REF: St Marys Close Hurst Road Rustington BN16 3AP
Application Number R/64/17/PL

I would like to put on record my objection to the proposed changed development as per the above application reference.

Reference:- PLANNING APPLICATION R/64/17/PL
FOR ST MARY'S CLOSE IN HURST ROAD

Drg No: 151117_SS-01 Rev: D

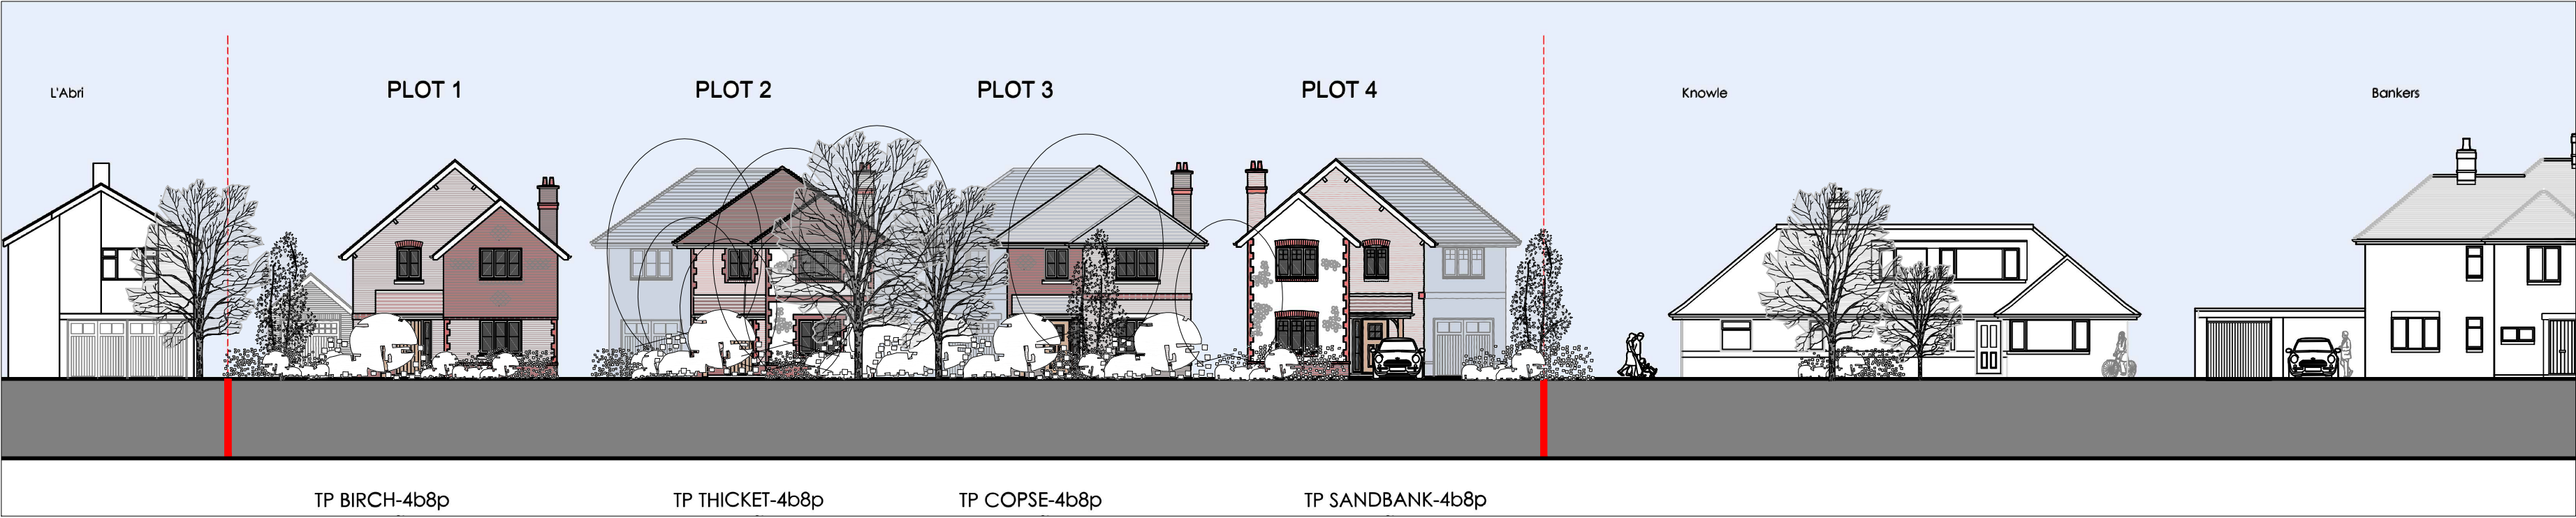
The proposed development of St. Mary's Close is squeezing four houses of identical design into an area where only three should go against the character of the road. This is highlighted by the fact that two of the proposed houses have their garages in the front gardens, in front of the building line. No other house in the road has a garage this way, which will set a precedent.
